Addendum No. 1

RE: Contract # C204471
WBS # 45446.3.1
FEDERAL-AID NO. NHS-0421(072)
Wilkes County (U-5312)
US-421 FROM EAST OF NC-16 TO US-421 BUS.

The following revisions have been made to the Utility Construction Plans.

WATER SHEETS LAYOUT (UC-19 - UC-33)

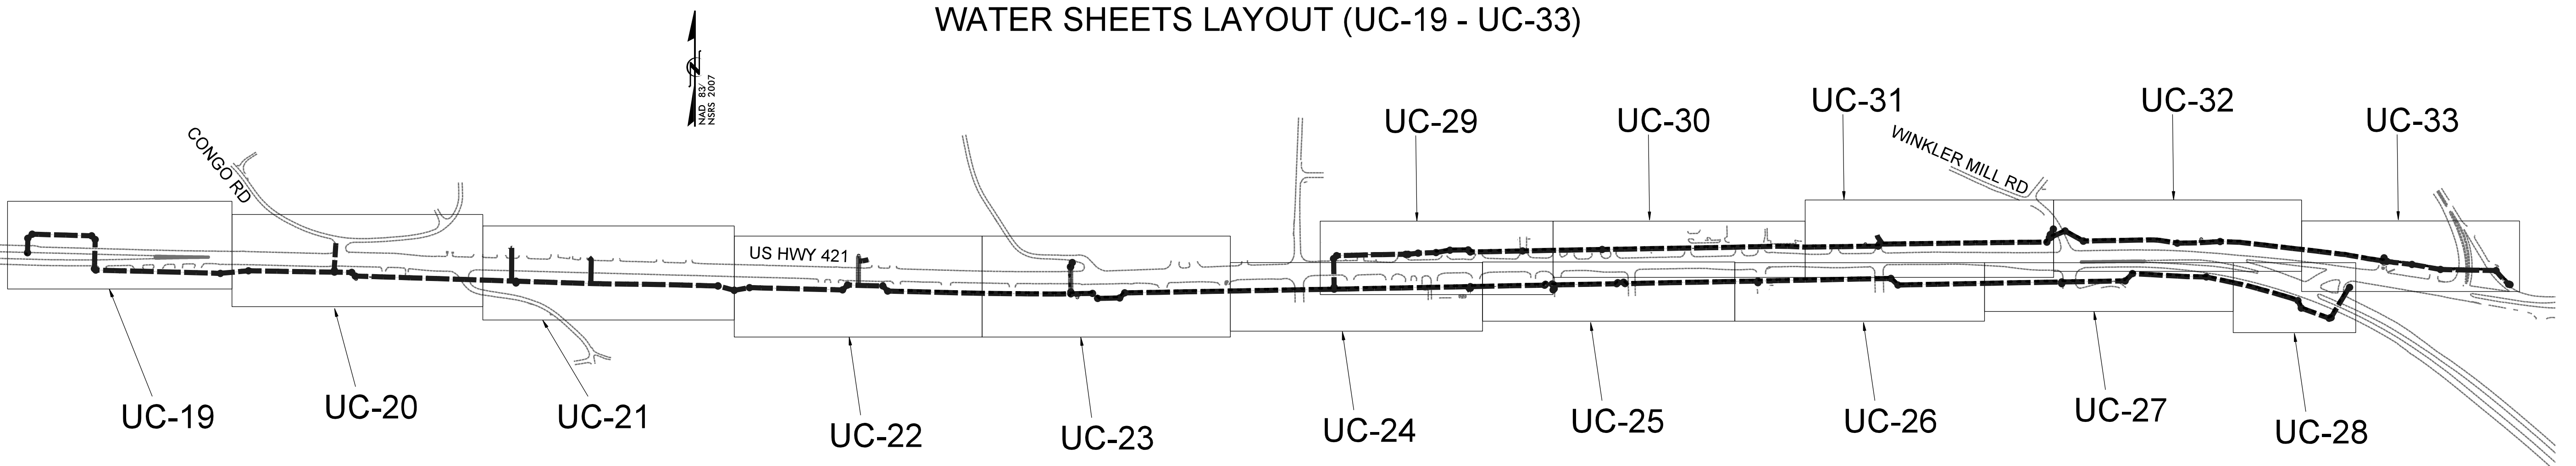
Sheet No.	Revision
UC-2 thru UC-33	All sheets within the Utility Construction Plan set affixed with a Professional Engineer seal and signature have been revised with a digitally signed signature and an execution date of 11/06/23.
UC-4A (New Sheet)	Sewer Sheet Layout (UC-4 thru UC-18).
UC-19A (New Sheet)	Water Sheet Layout (UC-19 thru UC-33).
UC-19	Provided extra clearance between water and sewer lines. Revised Note #1 to state "Waterline material shall be DIP-Class 350 (All Open Trench Installations), HDPE-DR7 (Directional Bore Installations), Copper (Service Installations)".
UC-20	Revised Note #1 to state "Waterline material shall be DIP-Class 350 (All Open Trench Installations), HDPE-DR7 (Directional Bore Installations), Copper (Service Installations)".

PROJECT REFERENCE NO.	U-5312	SHEET NO.	UC-22
DESIGNED BY:	B. CLAWSON		
DRAWN BY:	R. MOSS		
CHECKED BY:	B. CLAWSON		
APPROVED BY:			
REVISIED:	5/9/23 11/2/23	MUNICIPAL ENGINEERING SERVICES COMPANY, PA.	
P.O. BOX 97 GARNER, NC 27529 (919) 772-5393		UTILITY CONSTRUCTION PLANS ONLY

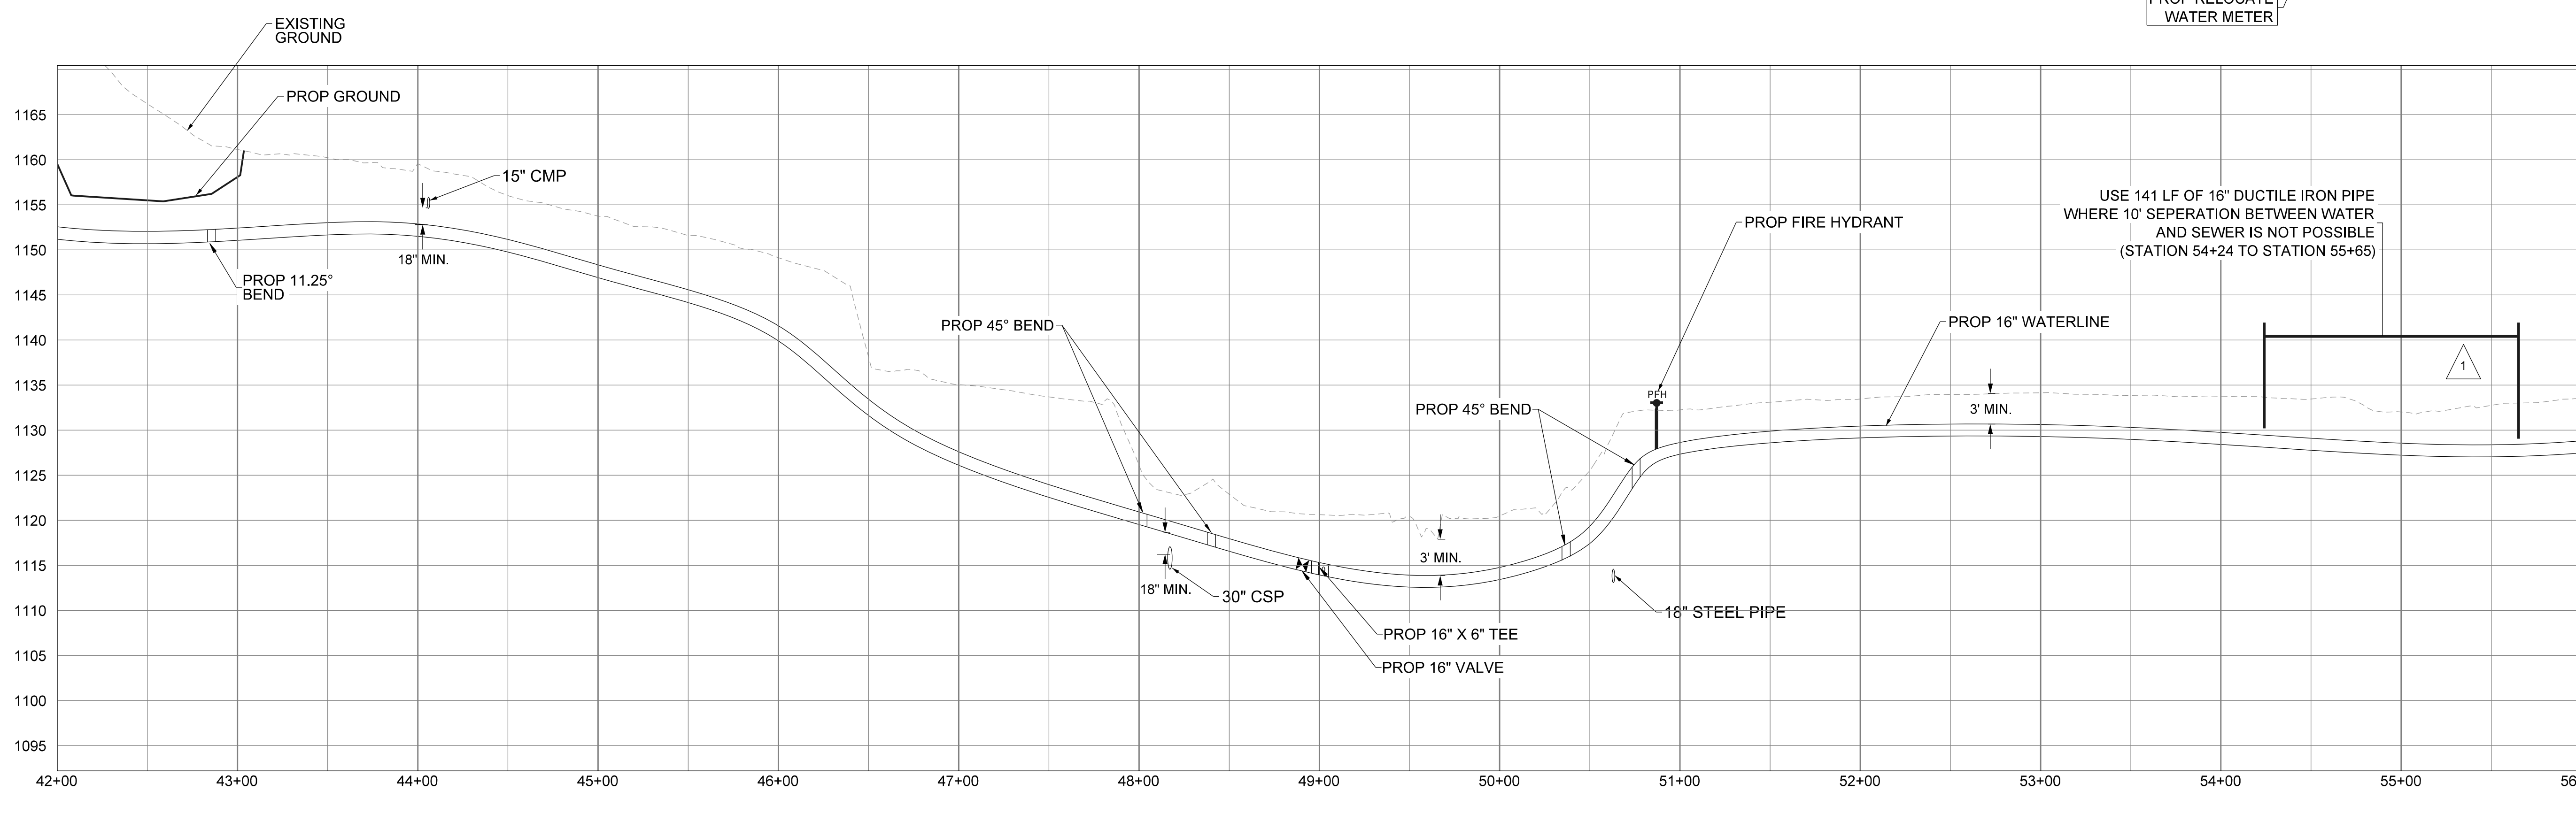
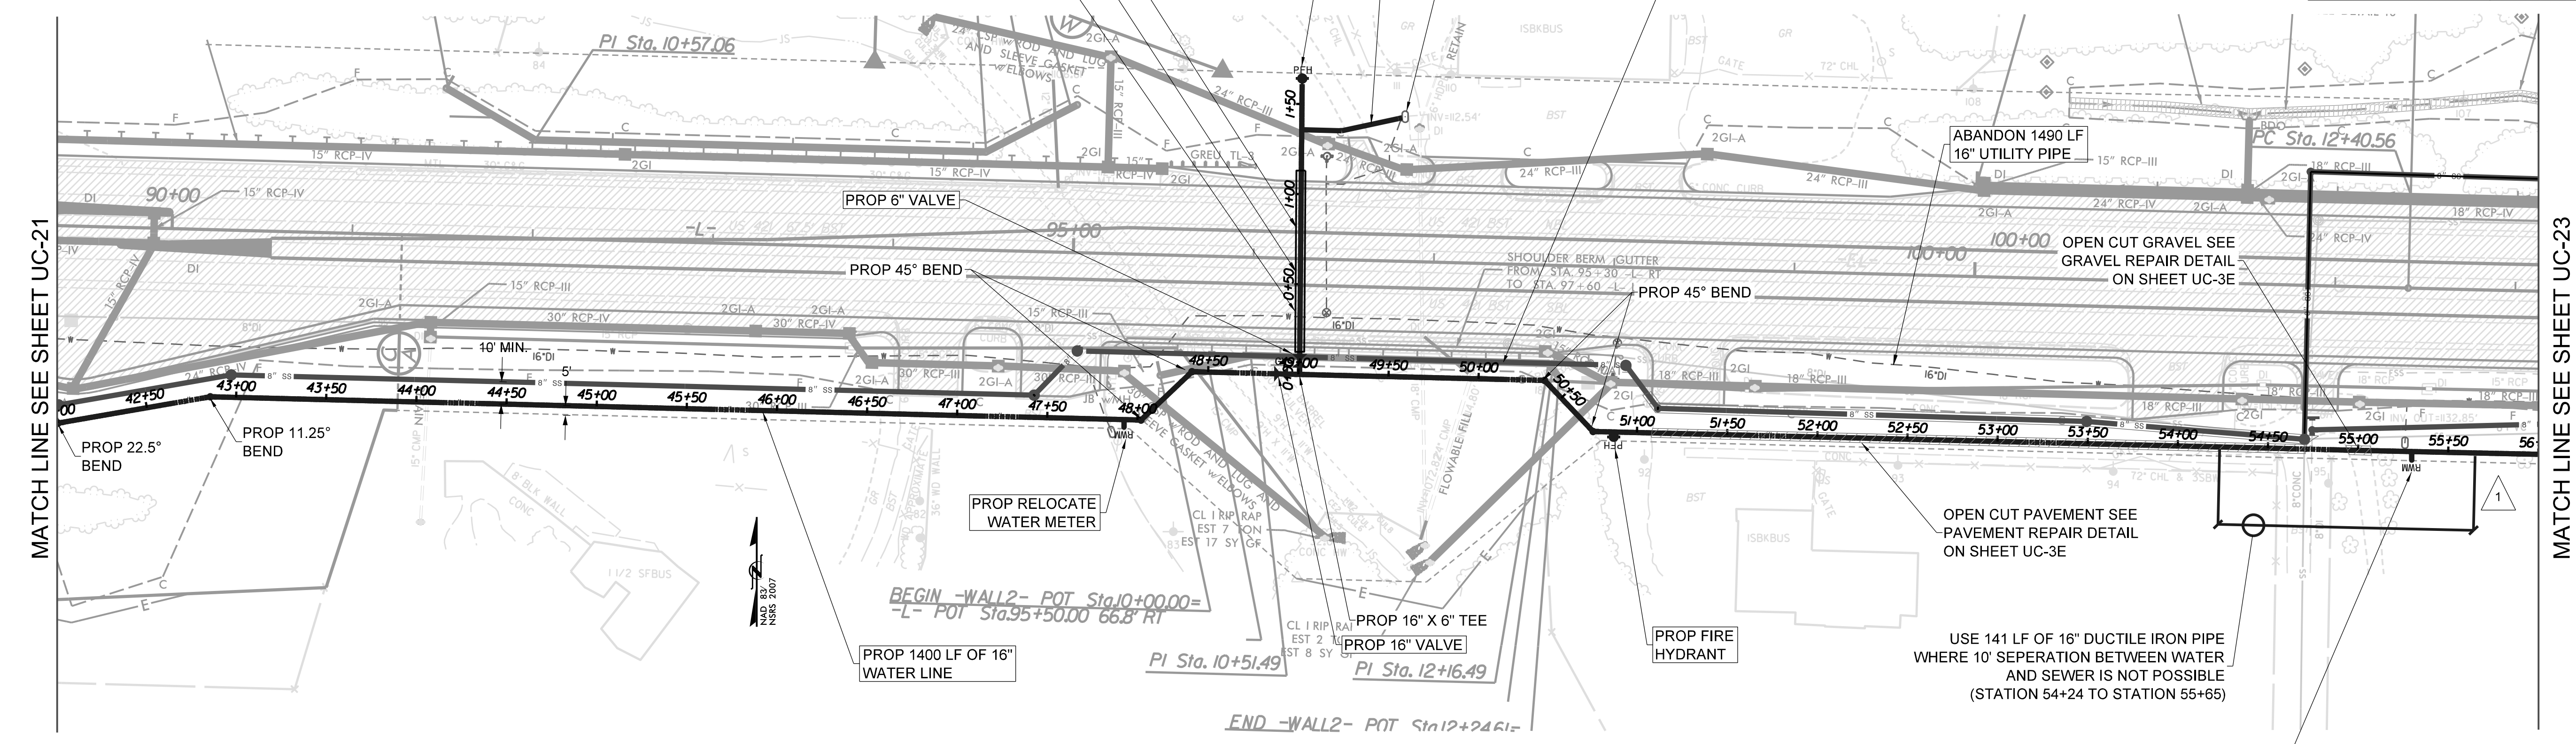
Sheet No.	Revision
UC-21	Revised Note #1 to state "Waterline material shall be DIP-Class 350 (All Open Trench Installations), HDPE-DR7 (Directional Bore Installations), Copper (Service Installations)". Labels added for Proposed 16" Valve and Proposed Fire Hydrant.
UC-22	Revised Note #1 to state "Waterline material shall be DIP-Class 350 (All Open Trench Installations), HDPE-DR7 (Directional Bore Installations), Copper (Service Installations)".
UC-23	Revised Note #1 to state "Waterline material shall be DIP-Class 350 (All Open Trench Installations), HDPE-DR7 (Directional Bore Installations), Copper (Service Installations)".
UC-24 thru UC-25	North arrow added. Additional detail for benched exaction trenching provided in profile. Revised Note #1 to state "Waterline material shall be DIP-Class 350 (All Open Trench Installations), HDPE-DR7 (Directional Bore Installations), Copper (Service Installations)".

PROJECT REFERENCE NO.	U-5312	SHEET NO.	UC-26
DESIGNED BY:	B. CLAWSON		
DRAWN BY:	R. MOSS		
CHECKED BY:	B. CLAWSON		
APPROVED BY:			
REVISIED:	11-2-23		
MUNICIPAL ENGINEERING SERVICES COMPANY, PA.	P.O. BOX 97 GARNER, NC 27529 (919) 772-5393		
		UTILITY CONSTRUCTION PLANS ONLY

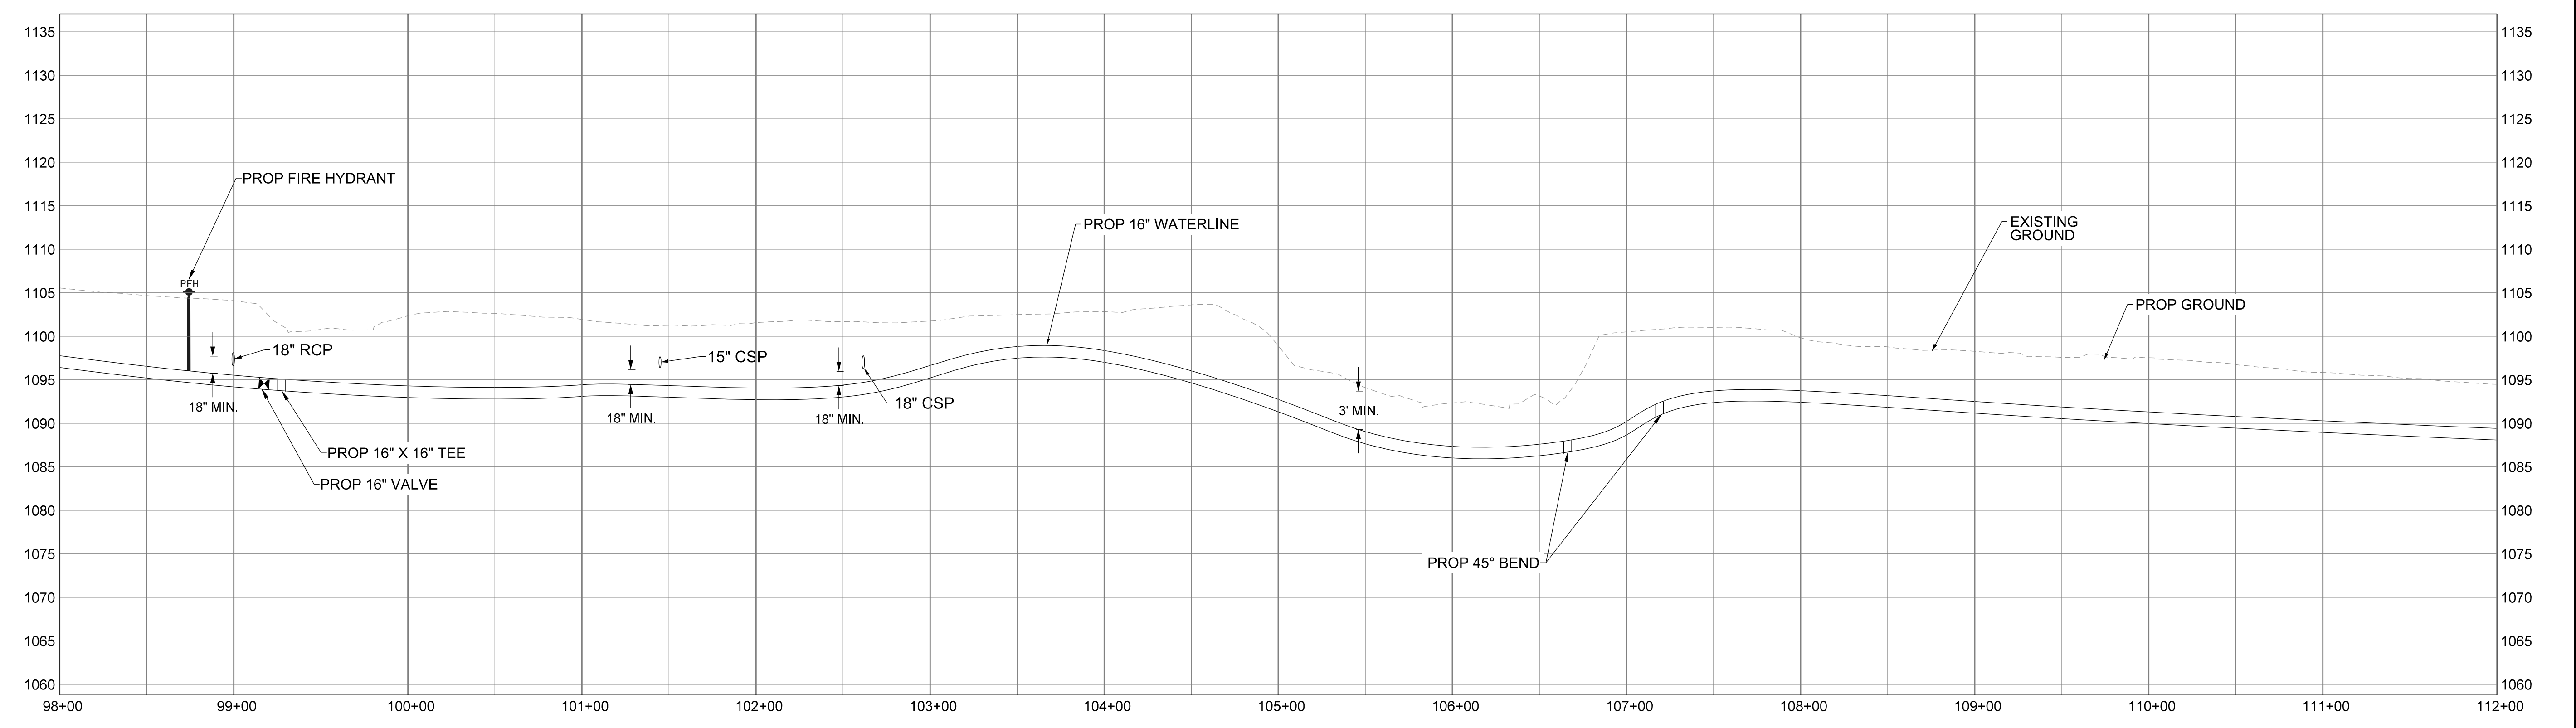
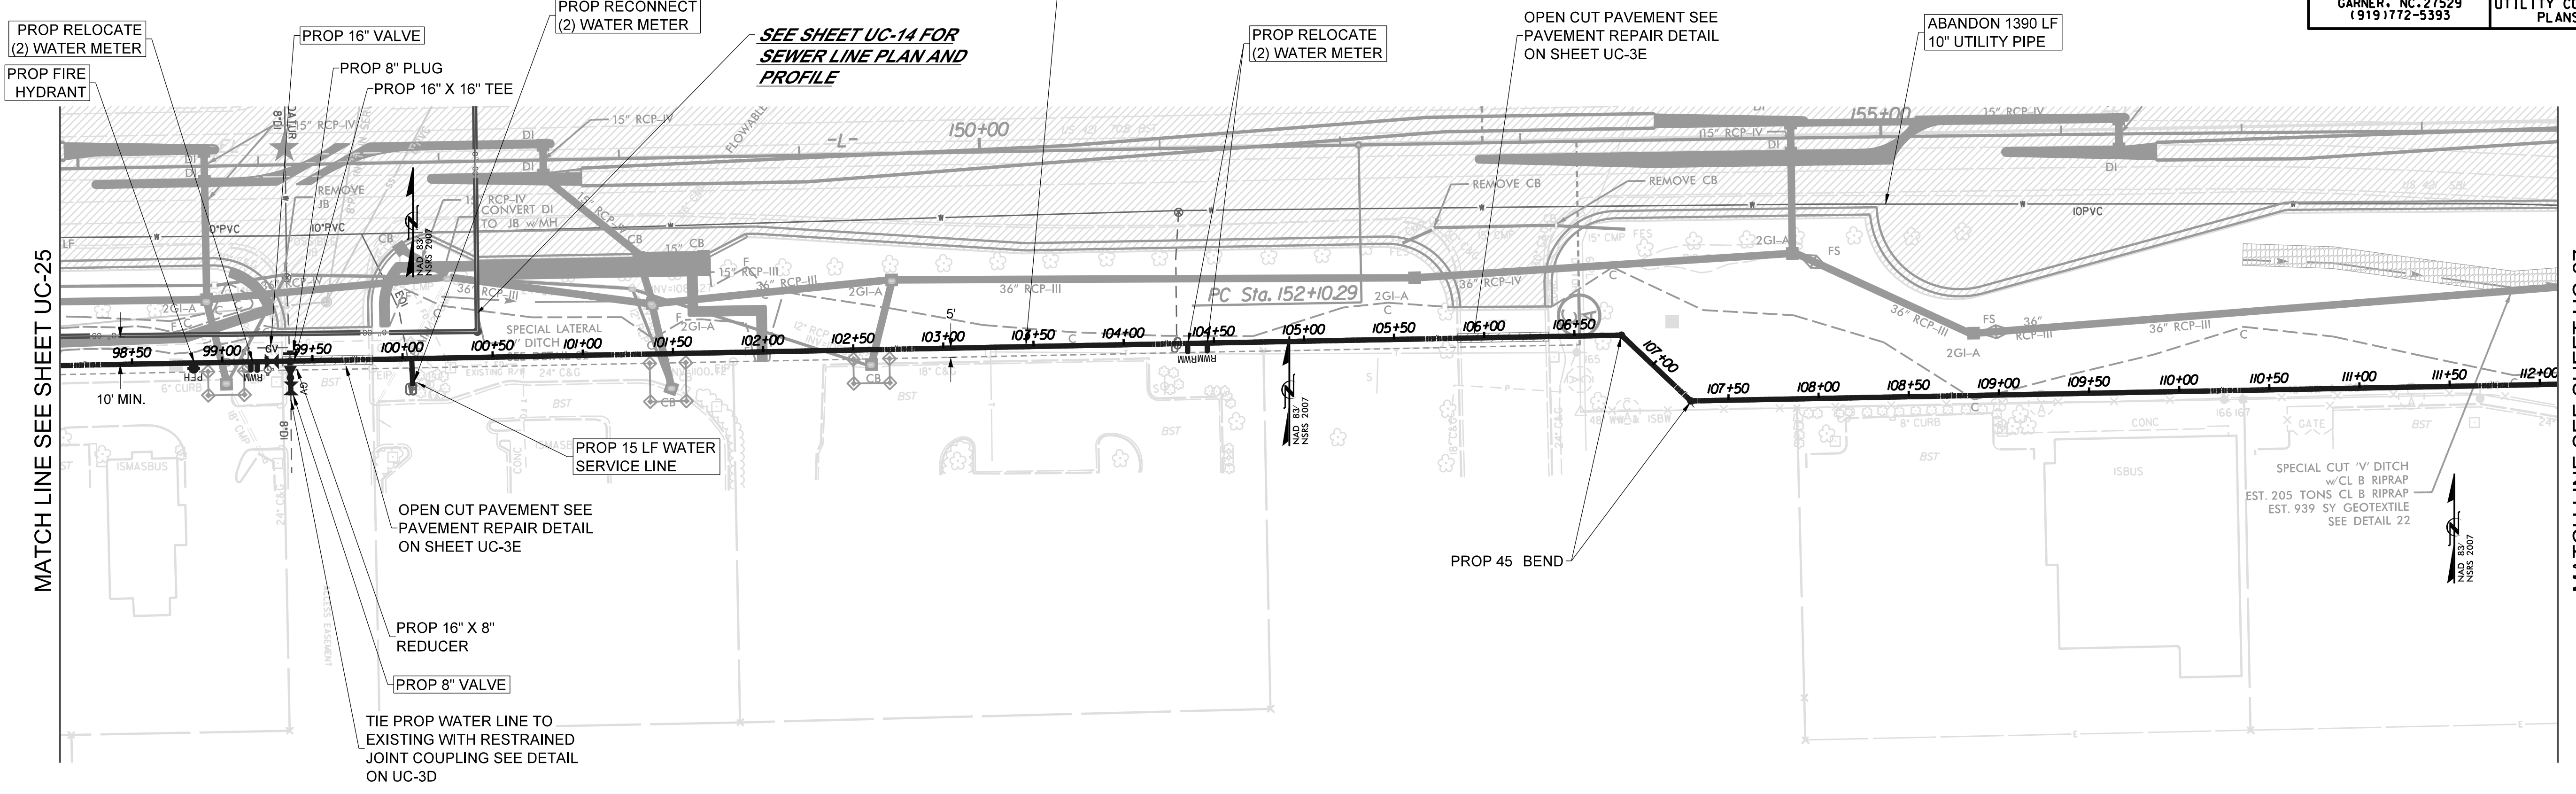
UC-26	Revised Note #1 to state "Waterline material shall be DIP-Class 350 (All Open Trench Installations), HDPE-DR7 (Directional Bore Installations), Copper (Service Installations)".
UC-27	North arrow added. Revised Note #1 to state "Waterline material shall be DIP-Class 350 (All Open Trench Installations), HDPE-DR7 (Directional Bore Installations), Copper (Service Installations)".
UC-28	North arrow added. Labels added in the profile. Revised Note #1 to state "Waterline material shall be DIP-Class 350 (All Open Trench Installations), HDPE-DR7 (Directional Bore Installations), Copper (Service Installations)".
UC-29	Vertical separation adjusted in profile. Revised Note #1 to state "Waterline material shall be DIP-Class 350 (All Open Trench Installations), HDPE-DR7 (Directional Bore Installations), Copper (Service Installations)".
UC-30 thru UC-33	Revised Note #1 to state "Waterline material shall be DIP-Class 350 (All Open Trench Installations), HDPE-DR7 (Directional Bore Installations), Copper (Service Installations)".
